CITY OF ALBUQUERQUE

April 12, 2024

**Re: Office Development
4700 Eubank Blvd. NE
30-Day Temporary Certificate of Occupancy
Transportation Development Final Inspection**
Architect's Stamp dated 10-25-22 (F21-D073)
Certification dated 04-11-24

AS101a

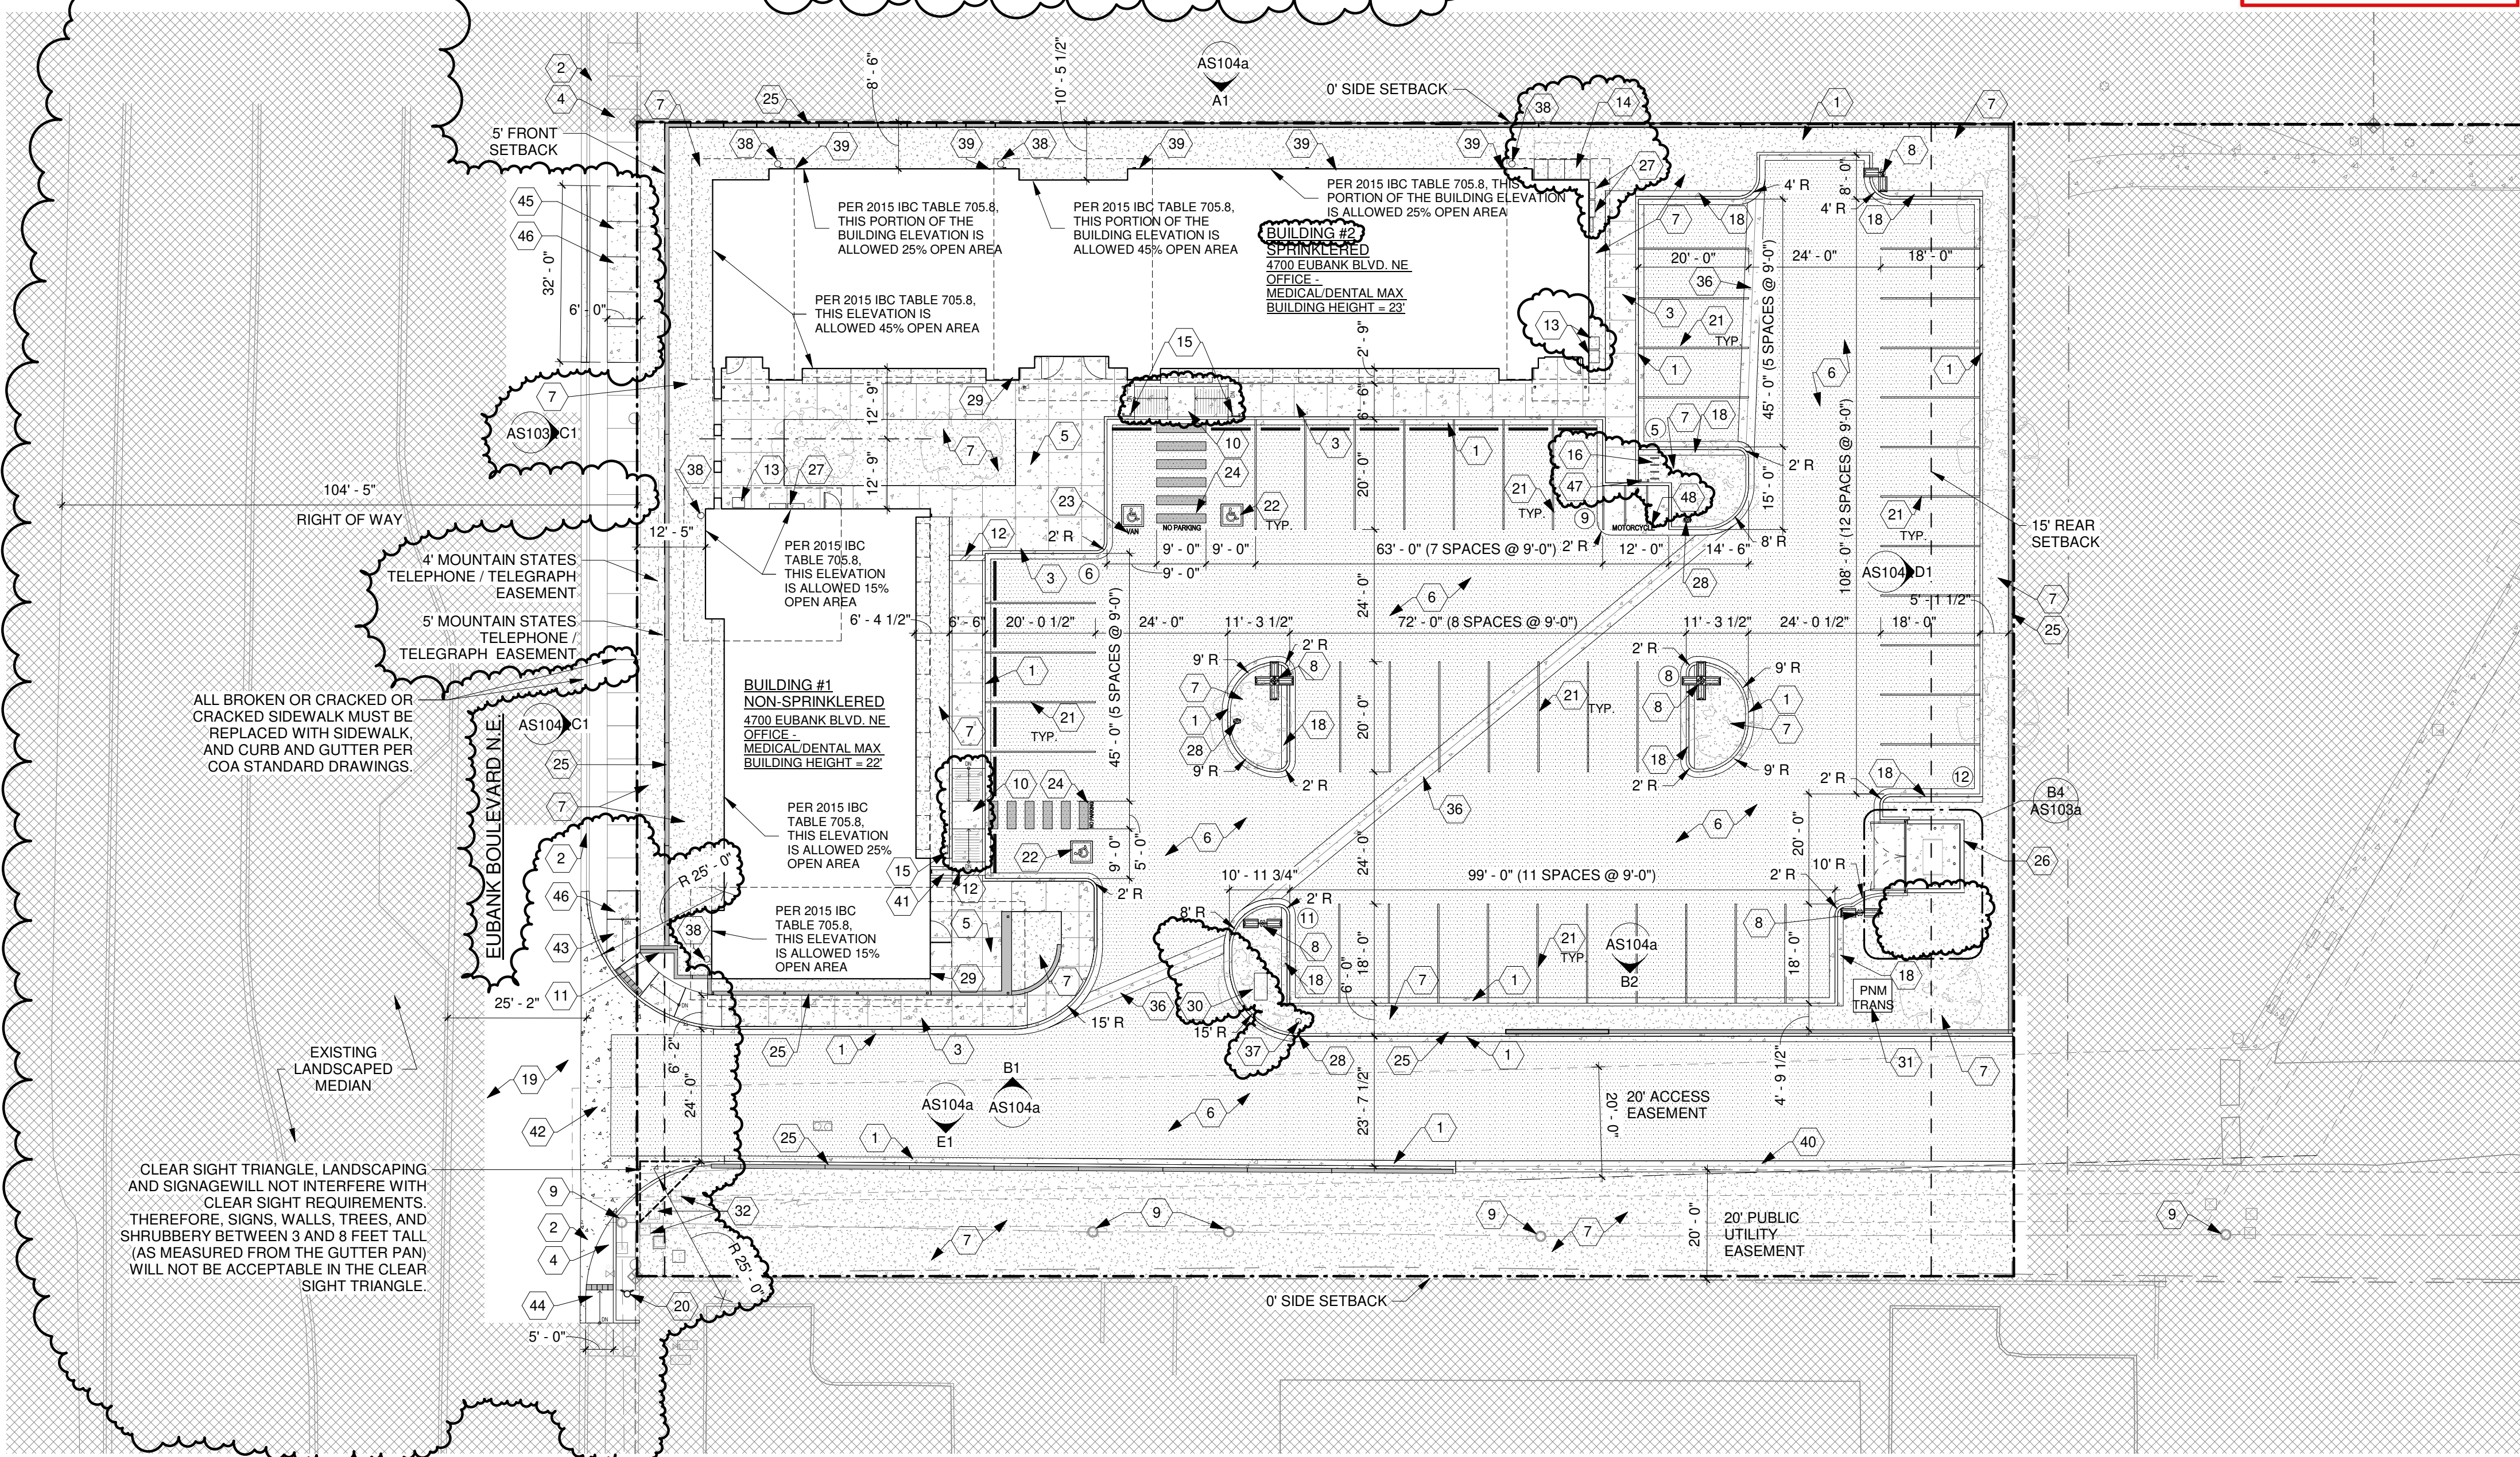
- Please install the ADA signs, The ADA accessible parking sign must have the required language per 66-7-352.4C NMSA 1978 **"Violators Are Subject to a Fine and/or Towing."** Please call out detail and location of signs.
- Install the Motorcycle parking sign.
- Remove all construction equipment and debris from the site.
